**WELWYN HATFIELD ACCESS GROUP**  
 THE COMMON ROOM  
 GROUND FLOOR  
 LEY HOUSE  
 LONG LEY  
 WELWYN GARDEN CITY  
 HERTFORDSHIRE AL7 2EX

**re: Planning Applications Received by Welwyn Hatfield Borough Council**

Application No.	Description and Location	Applicant/Agent
6/2016/1007/FULL	Alterations to external appearance to include, replacement entrance door and installation of new bollards and signage  KFC Comet Way Hatfield AL10 9TF	Ms J Edwards Hone Edwards Associates Second Floor Millars Three Southmill Road Bishops Stortford CM23 3DH

## WELWYN HATFIELD ACCESS GROUP'S RESPONSE TO PLANNING APPLICATION 6/2016/1007/FULL

drawing title  
**PROPOSED ELEVATIONS**

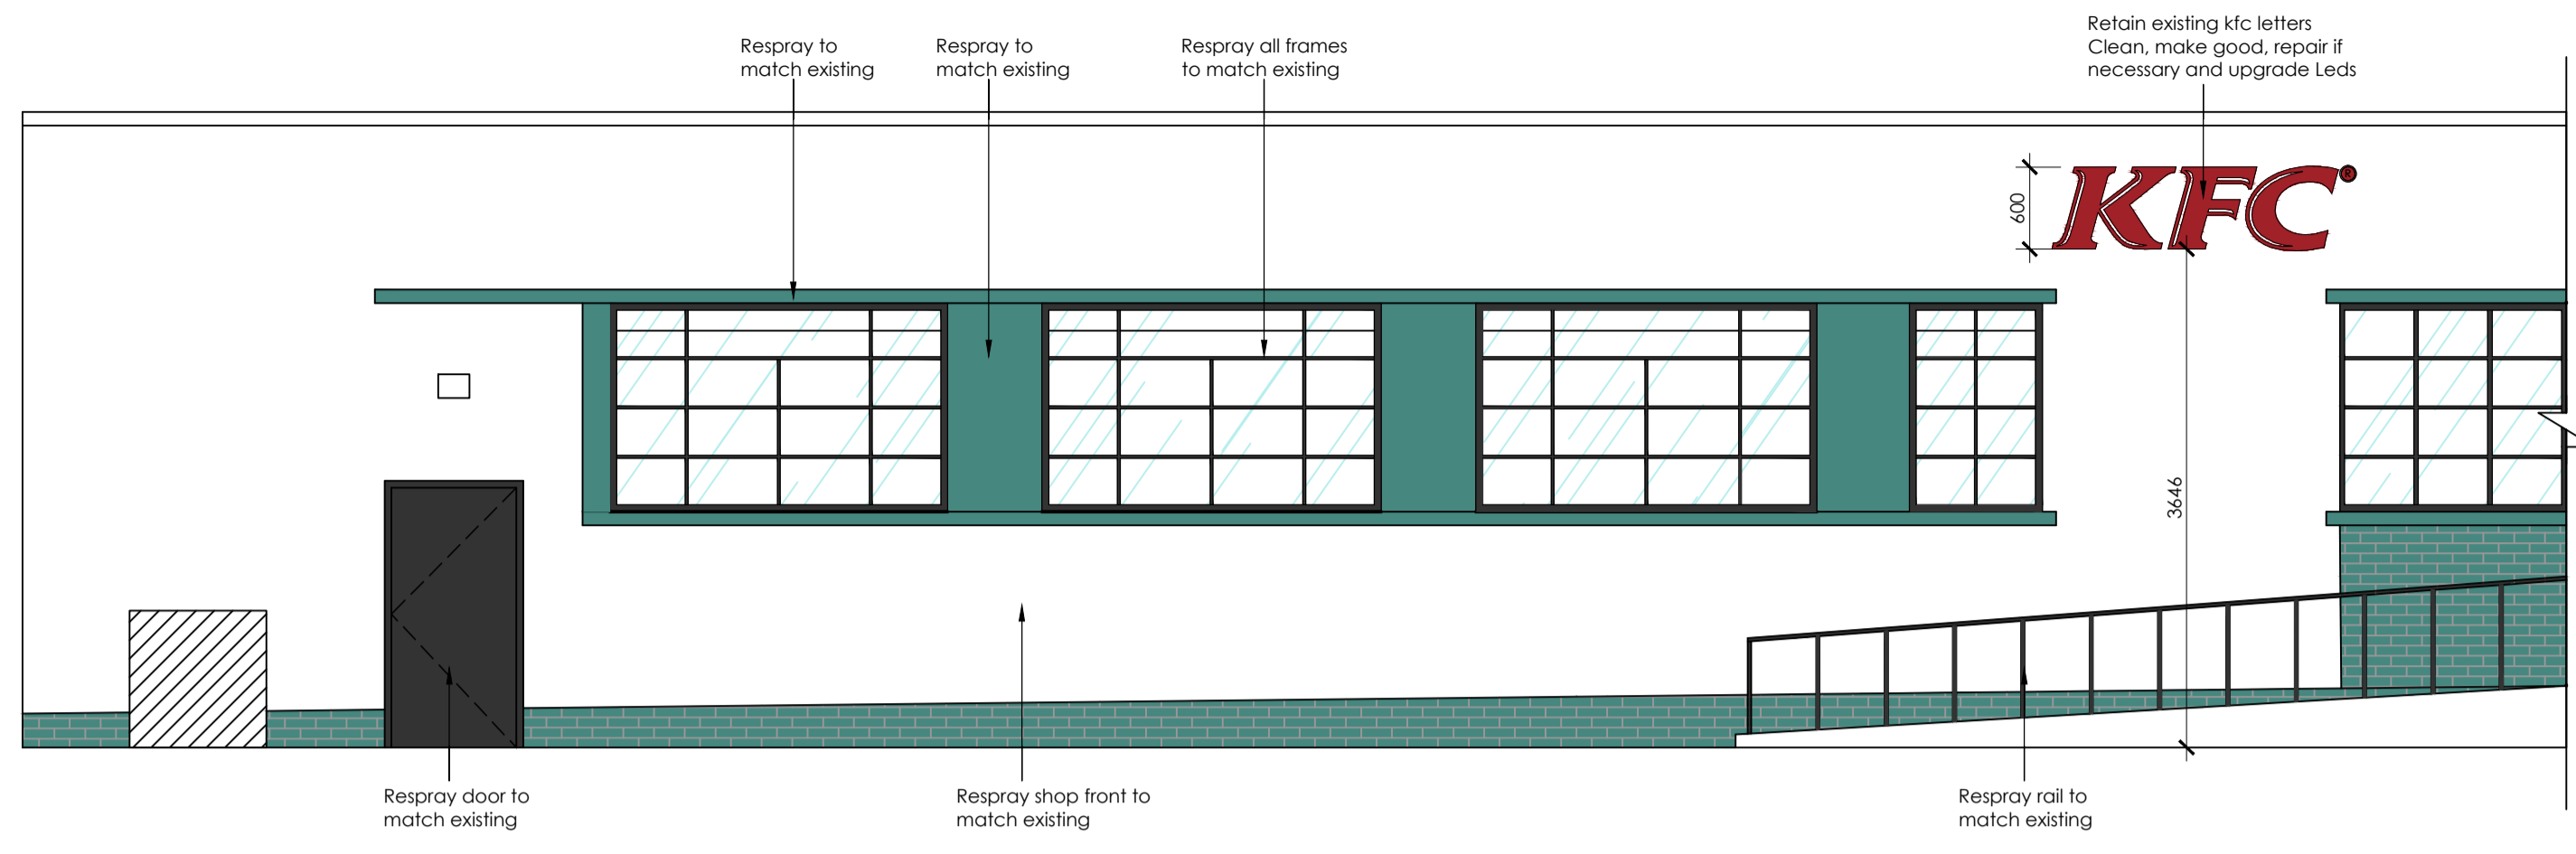
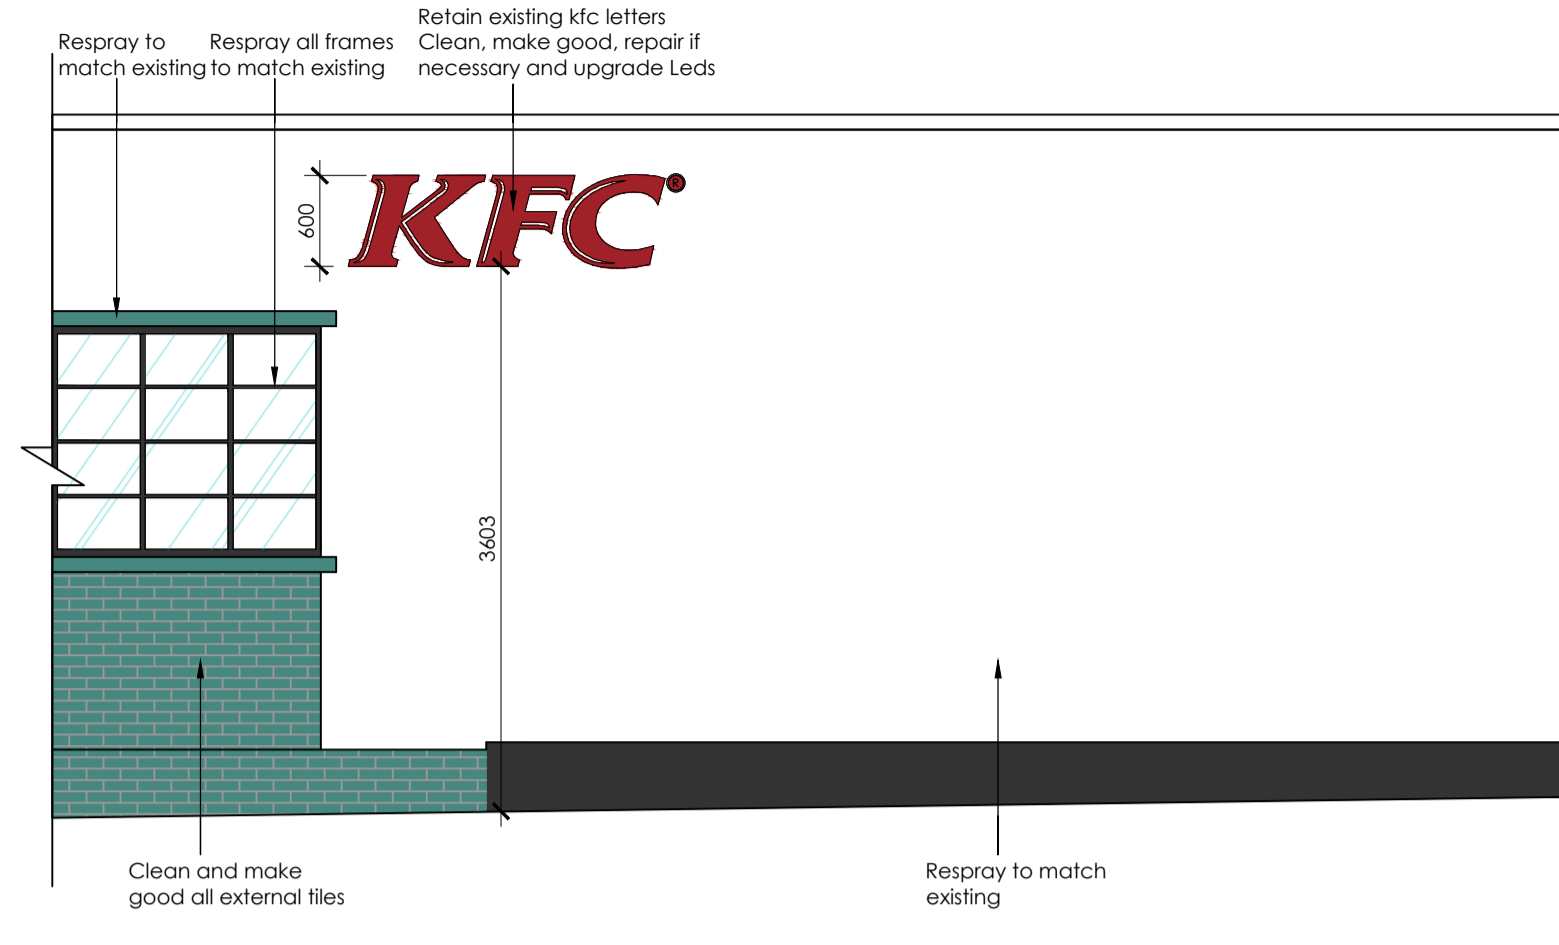
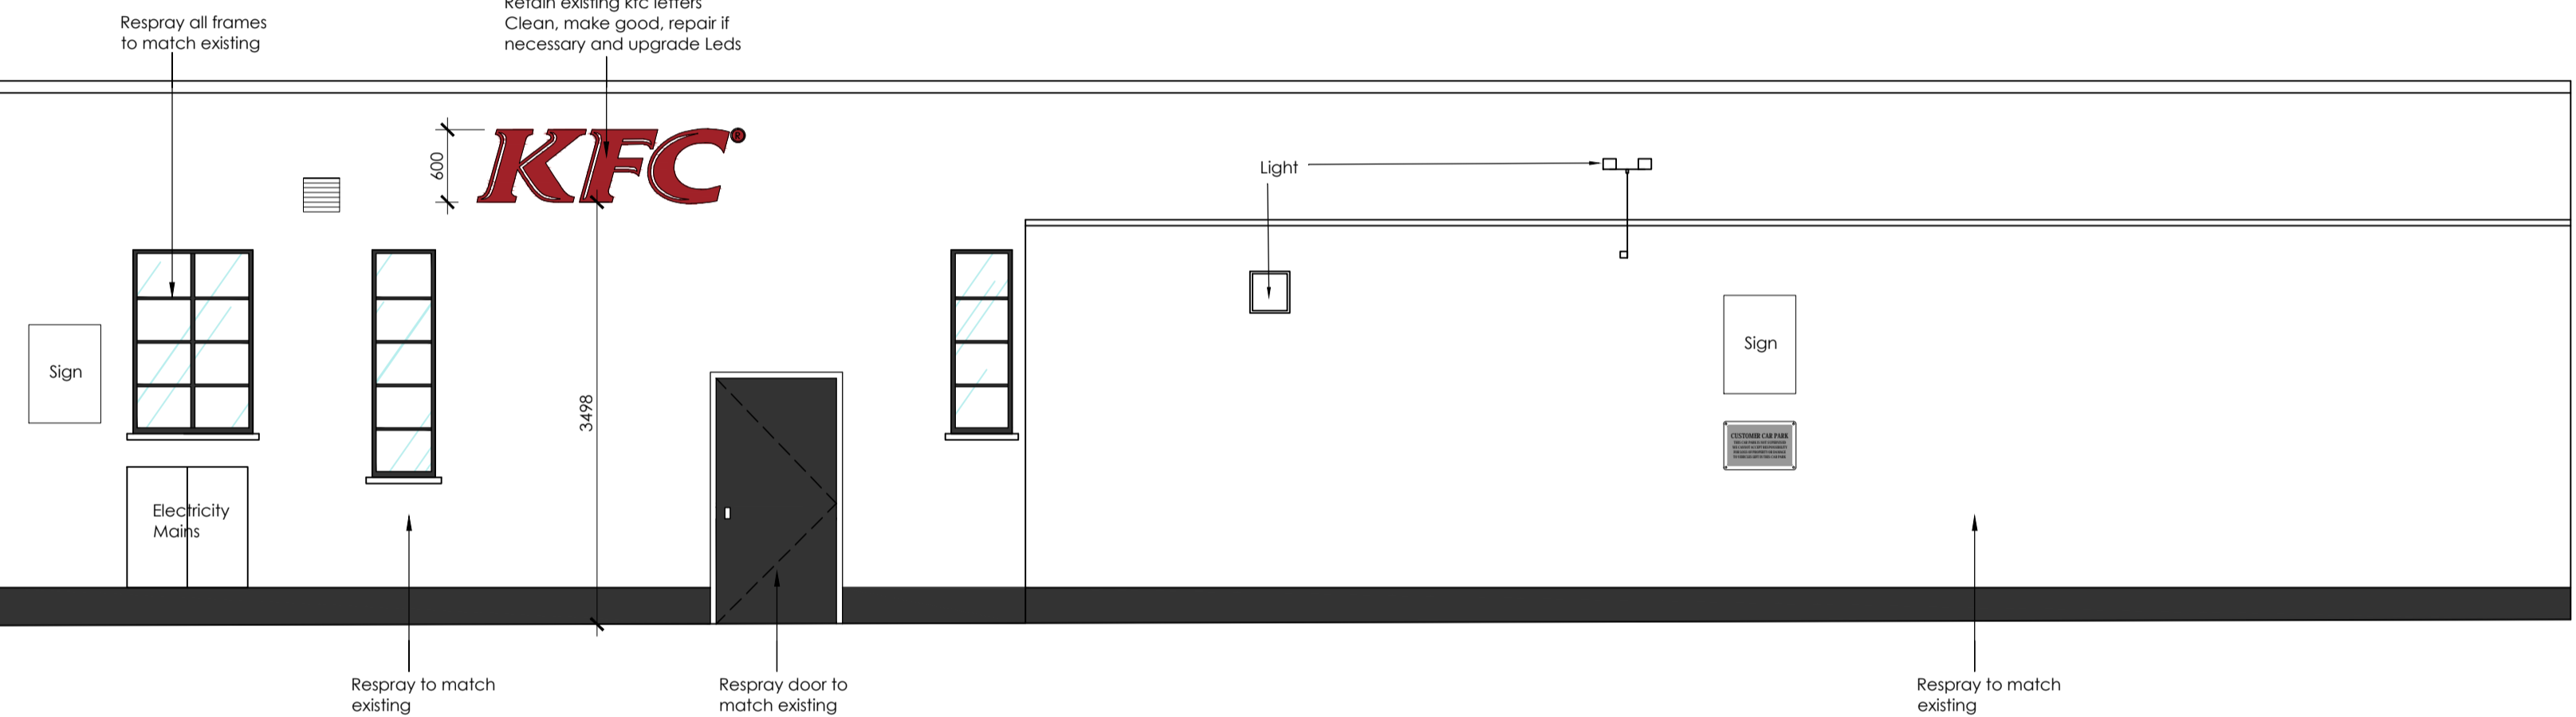
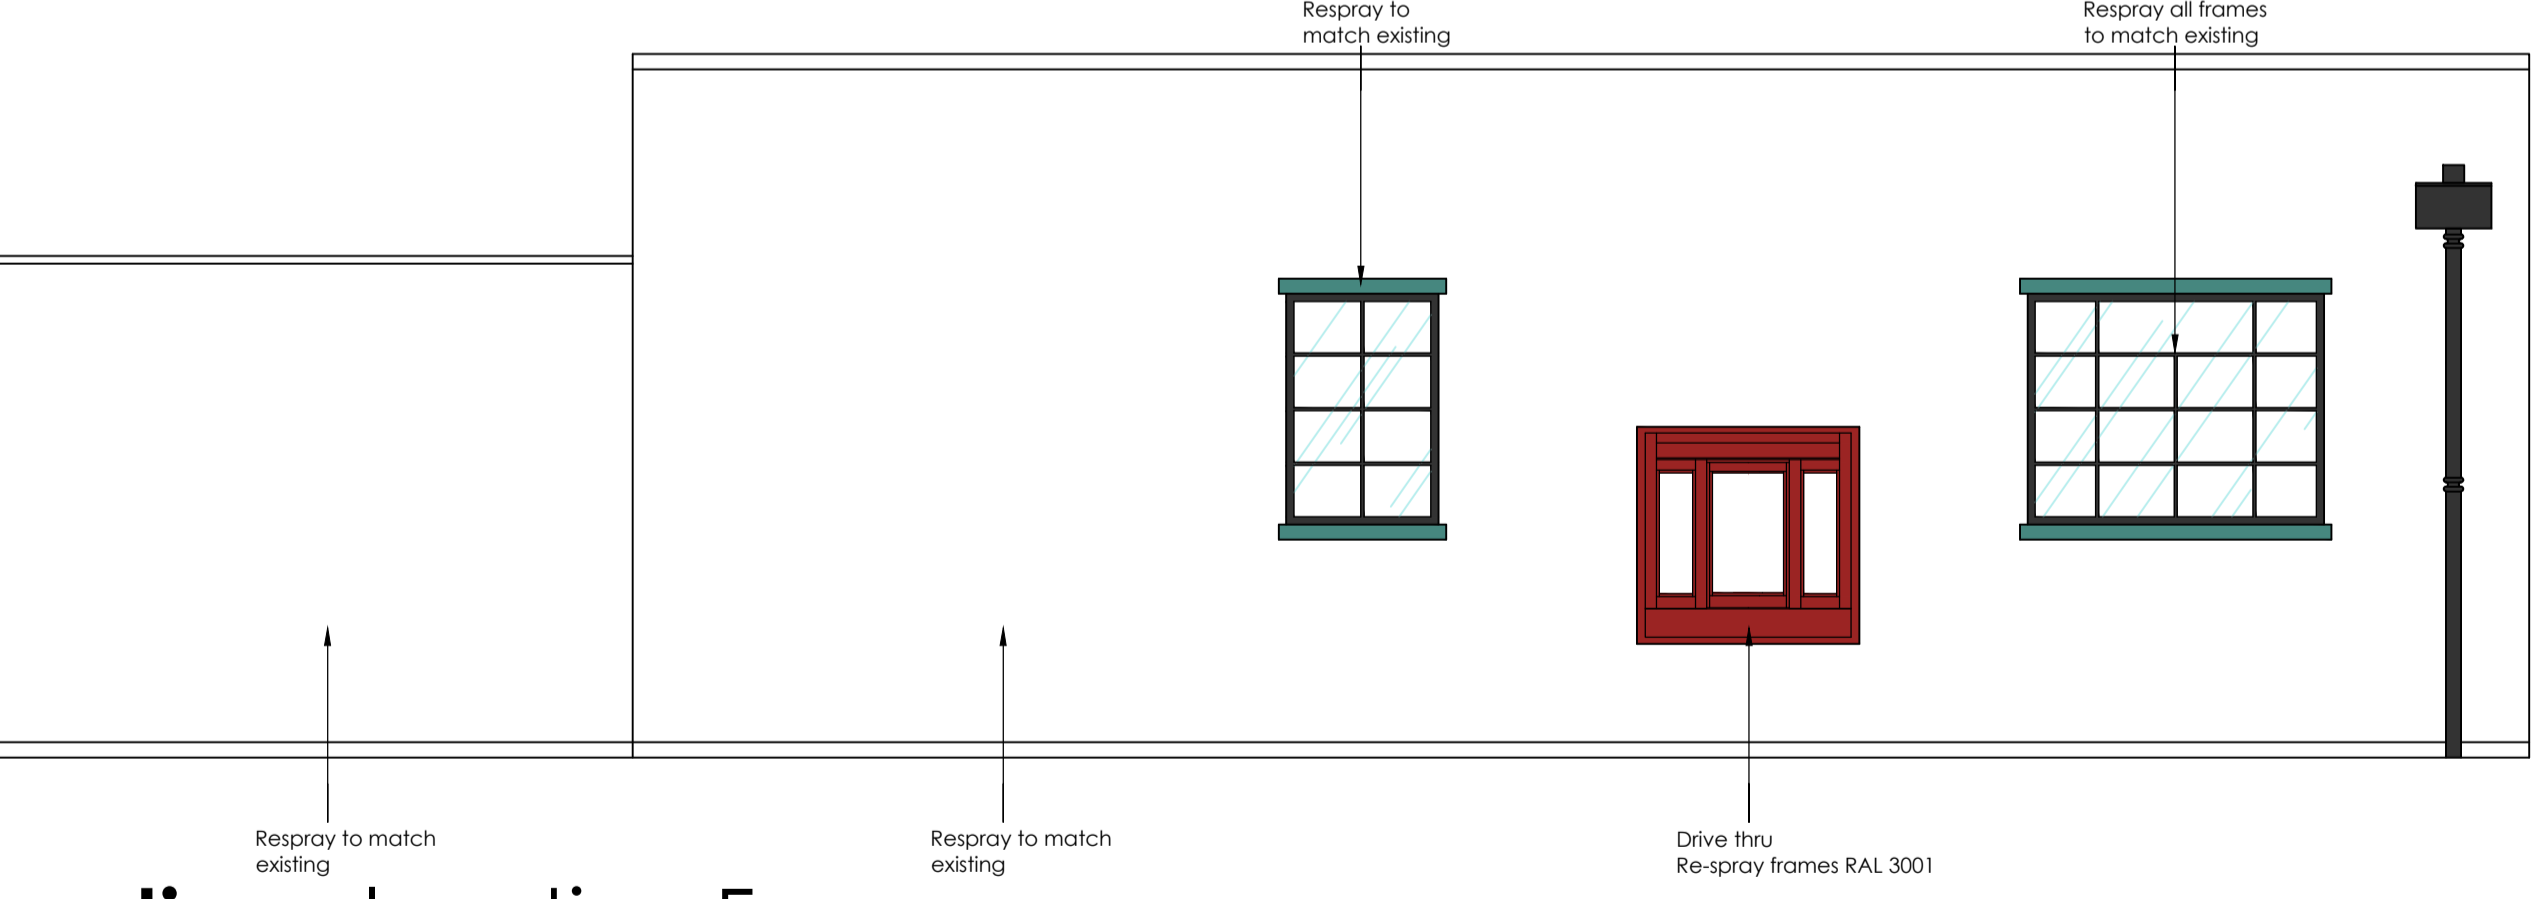
<b>DRAWIONG NO. 2542/G211 – PROPOSED ELEVATIONS</b>			We note the details outlined on this drawing.	<ol style="list-style-type: none"> <li>5 This confirms the installation of a new DDA Powered door assist. Does this make it automatic opening? We ask this because vertical offset door pull handles are specified which suggests manual opening.</li> </ol>
<b>DRAWIONG NO. 2542/G121 – PROPOSED SITE PLAN</b>			We note the details outlined on this drawing.	<ol style="list-style-type: none"> <li>6 This shows the provision of 2 disabled parking bays. What is the maximum travel distance from these to the front entrance?</li> </ol>
